FULL

Reference: H14-0450-22 **Date of Decision:** 20th June 2022
Applicant: P N Holdings Ltd.
Aaron Business Centre
Bittern Way
Boston
PE21 7NX
Location: Adj. 47 Milestone Lane Pinchbeck Spalding
Description: Residential Development - Erection of Dwelling (re-submission of H14-0811-21)

South Holland District Council hereby give notice that this application has been REFUSED for the above proposal for the following reason(s):

FLOOR PLANS & ELEVATIONS  
SITE & LOCATION PLANS.

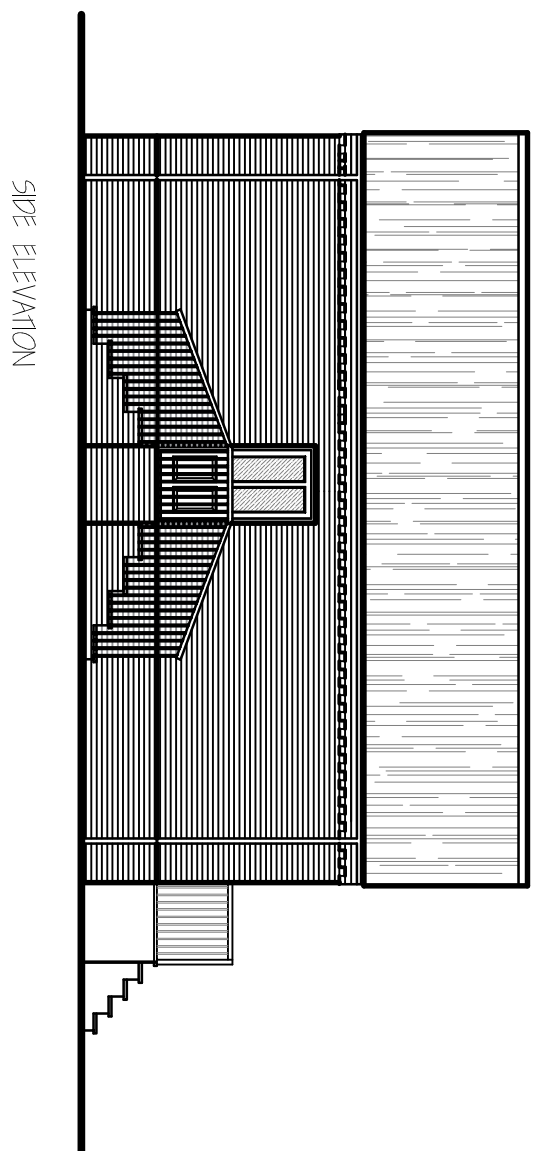
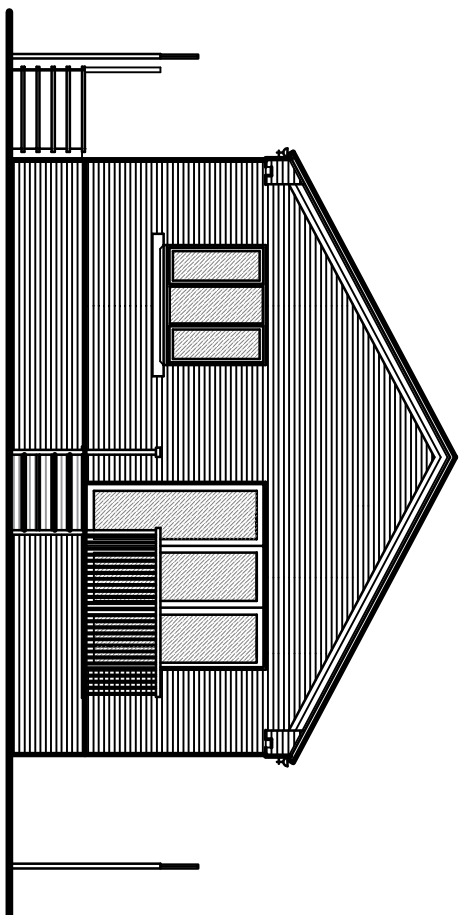
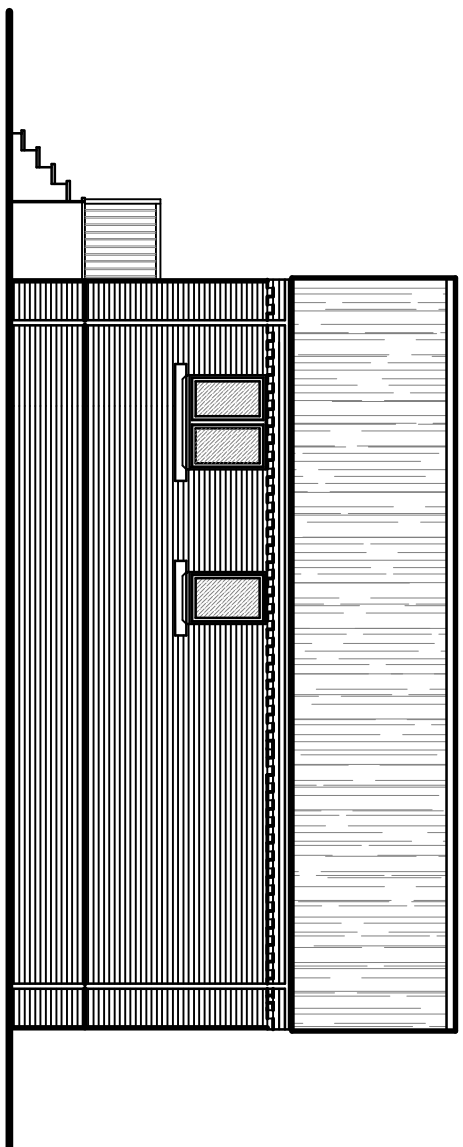
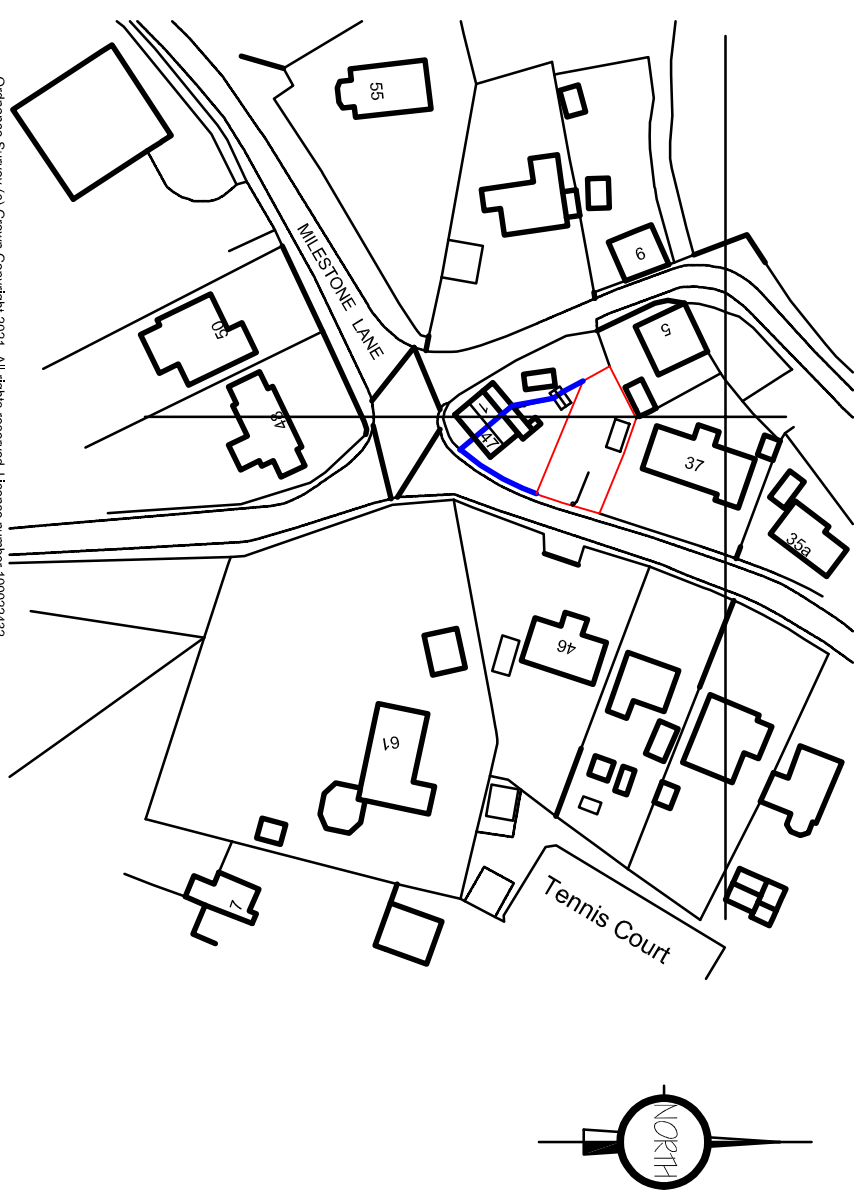
The impact is further exacerbated by the need to raise finished floor levels to 1.0m above existing ground level due to flood risk, which has been addressed by incorporating stepped access. This is at odds with the appearance of existing dwellings in the vicinity.

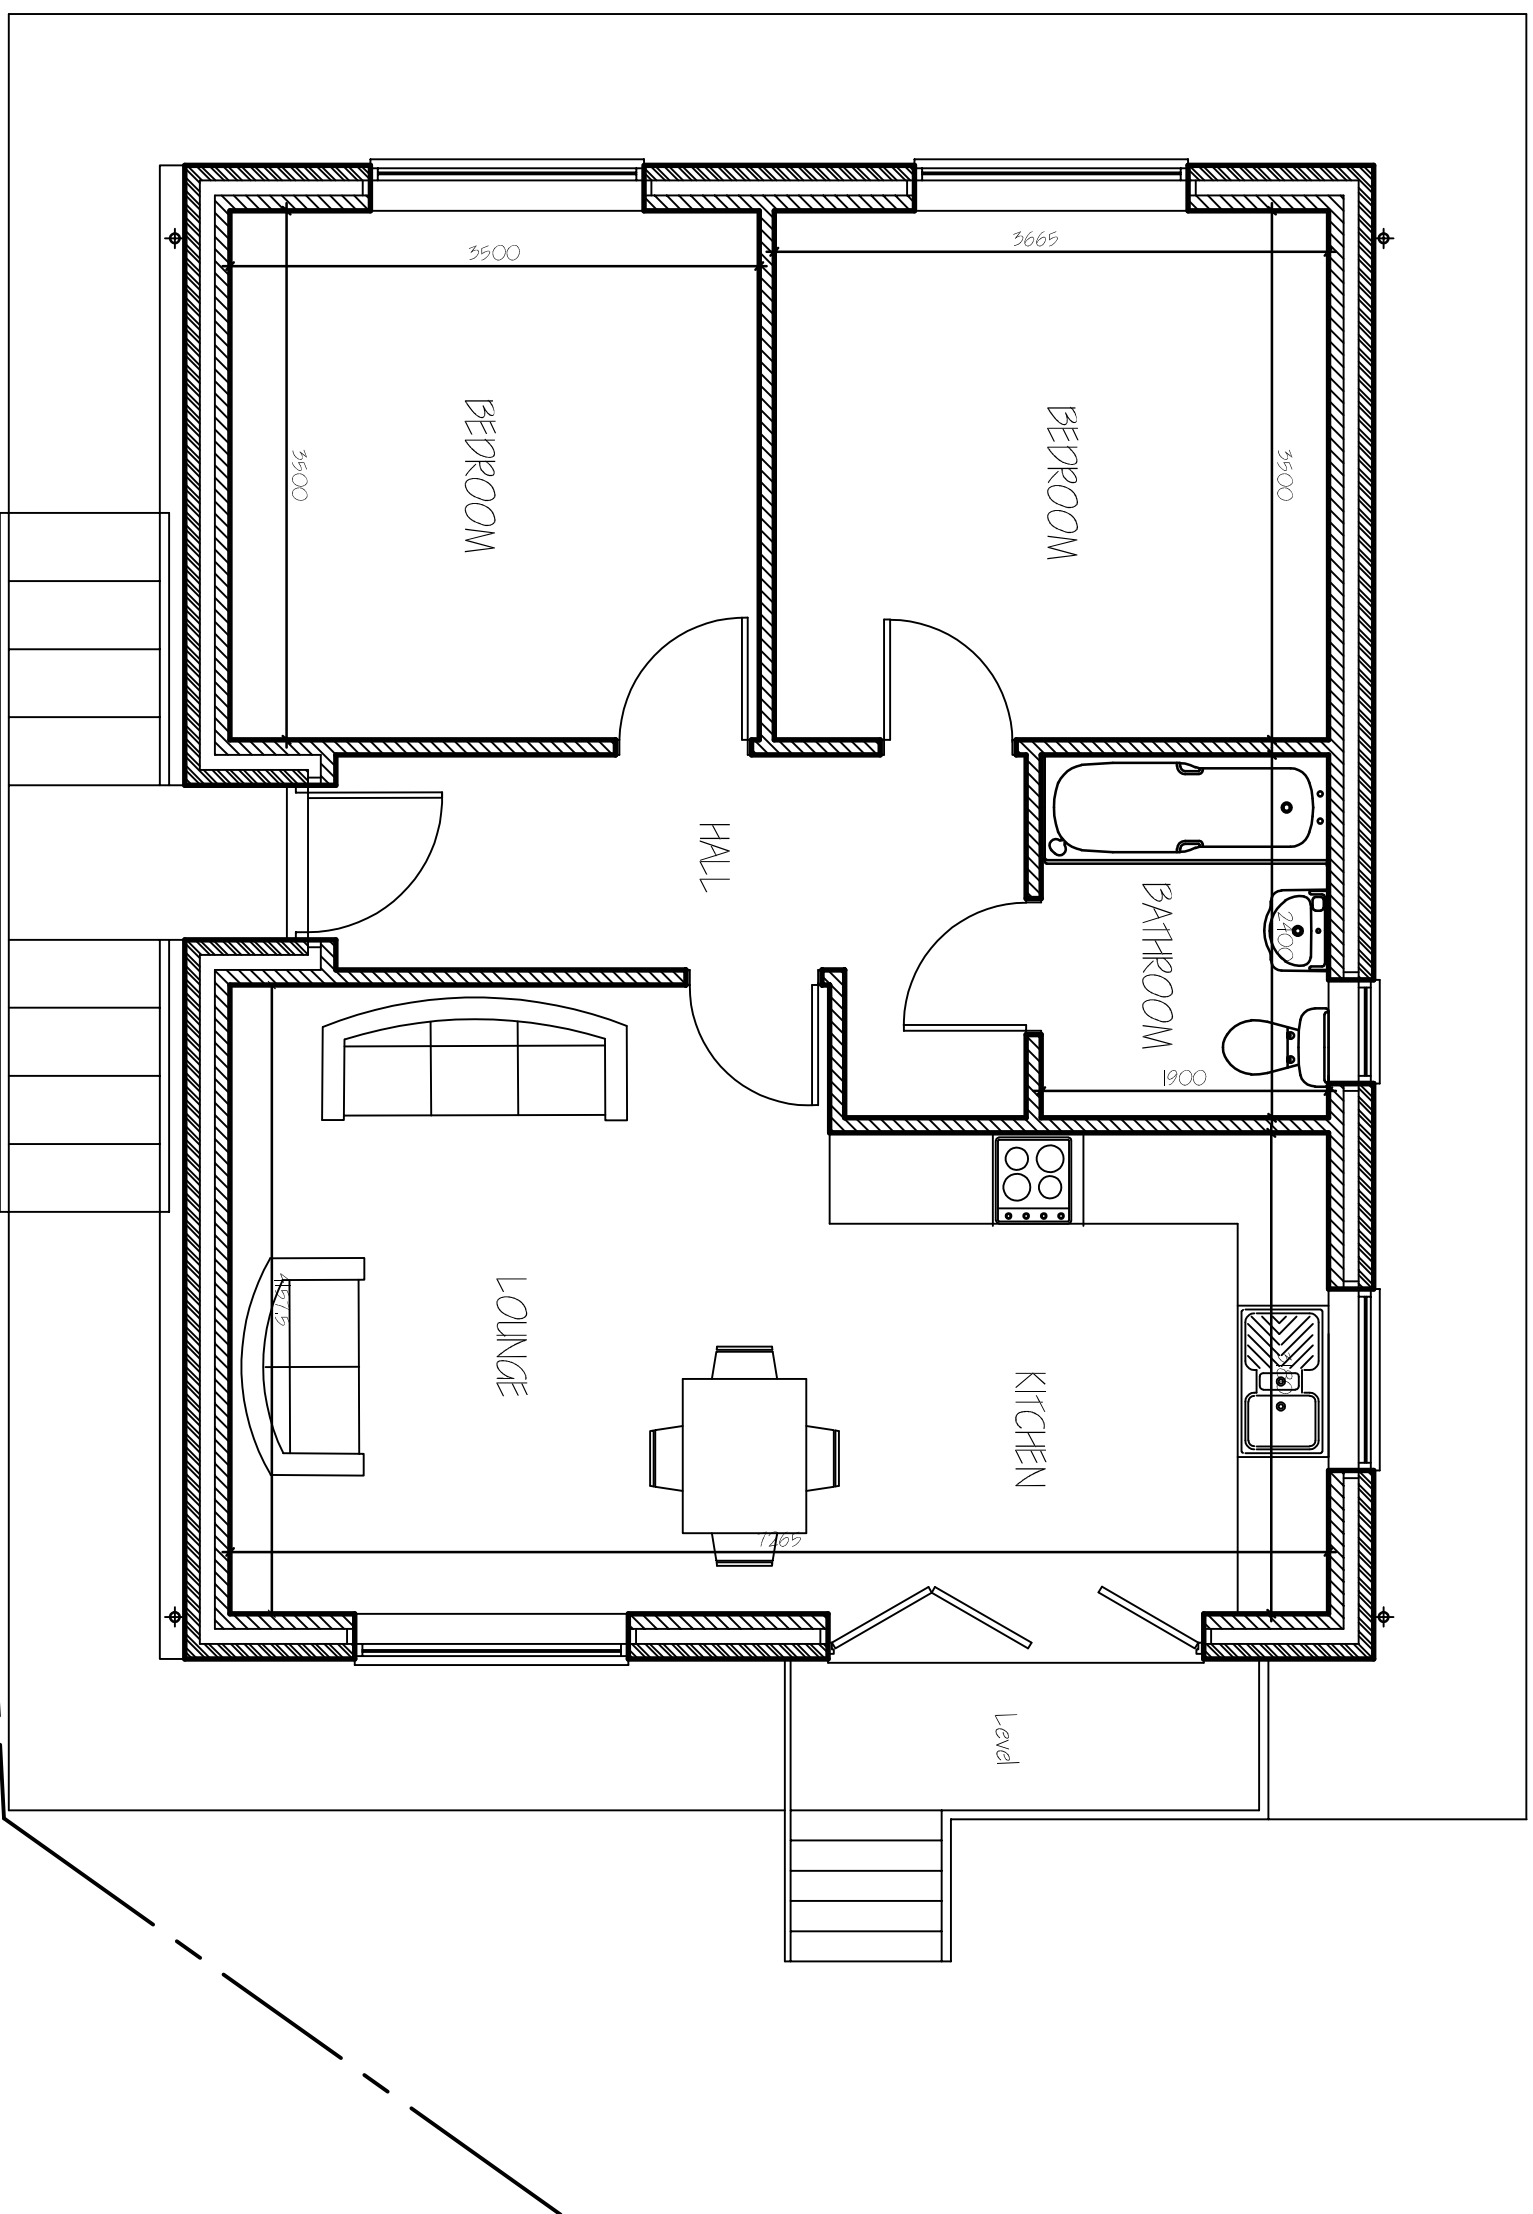
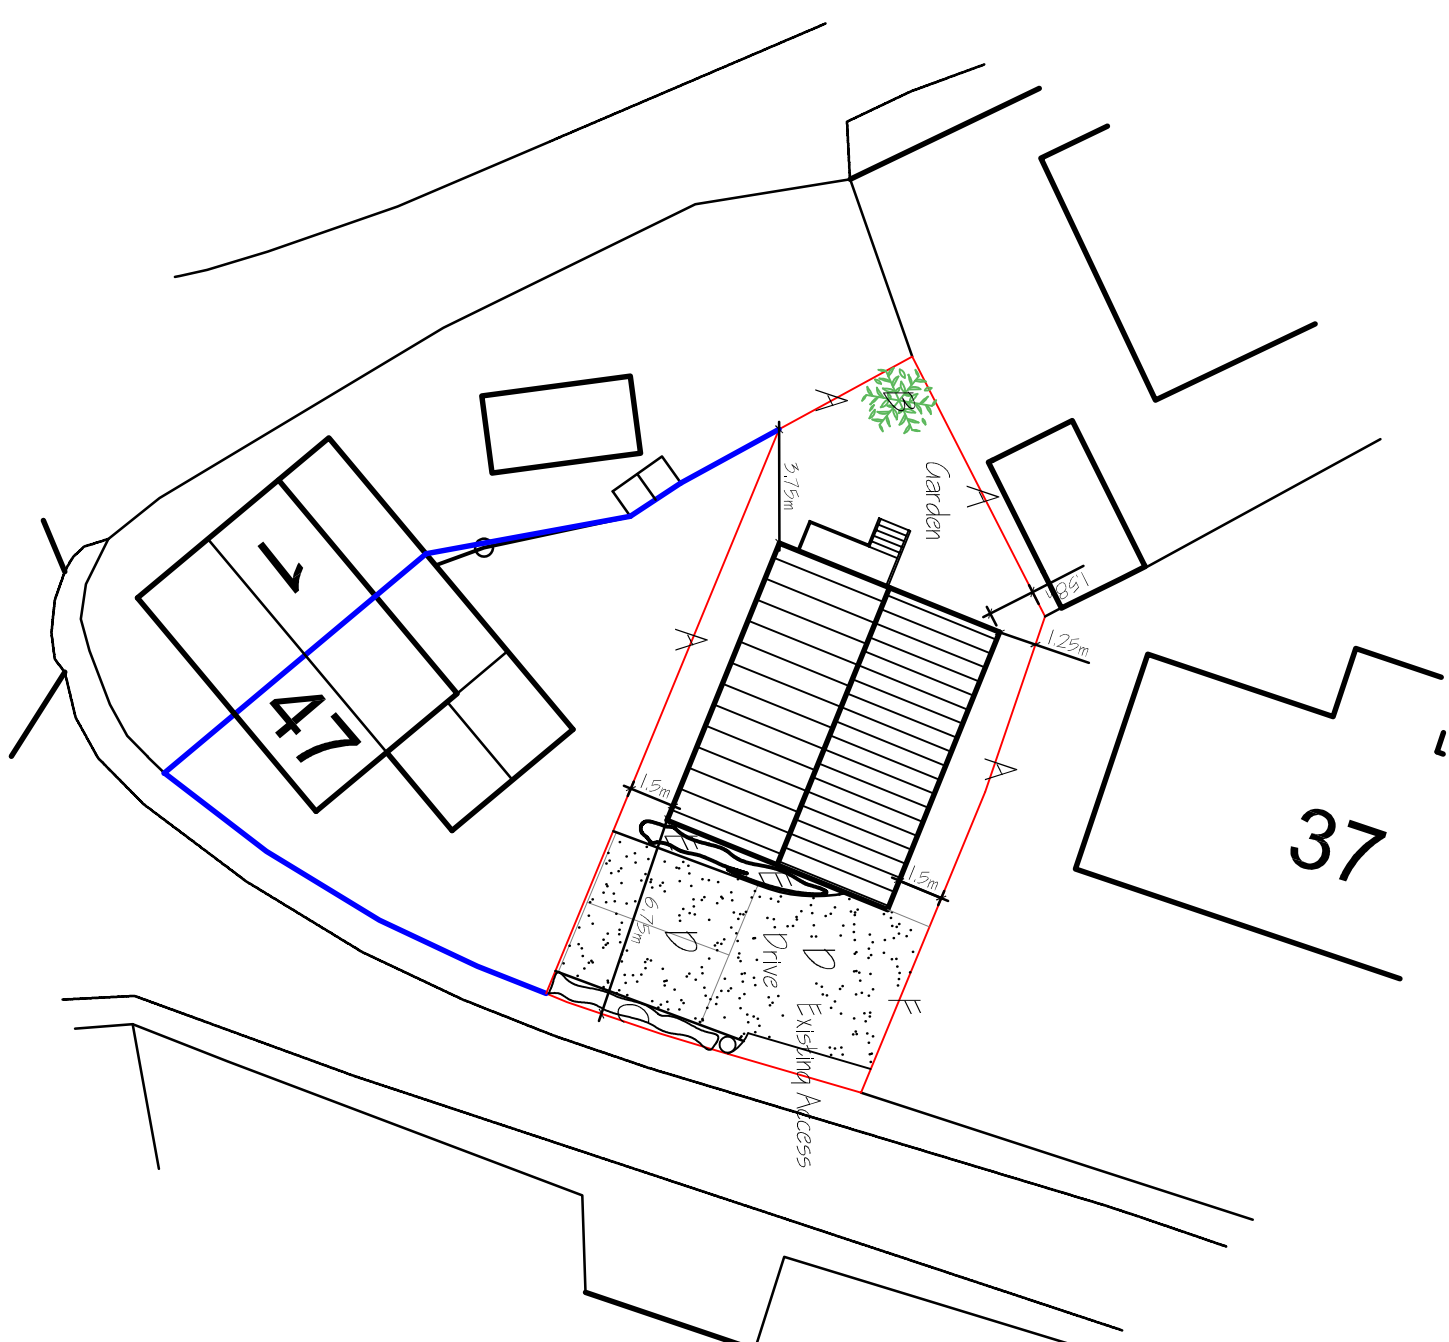
- 1 The proposed dwelling would constitute an unacceptable form of cramped development out of keeping with existing development in the area by virtue of existing residential development being sited within larger plots and the application site offering limited external space in comparison.
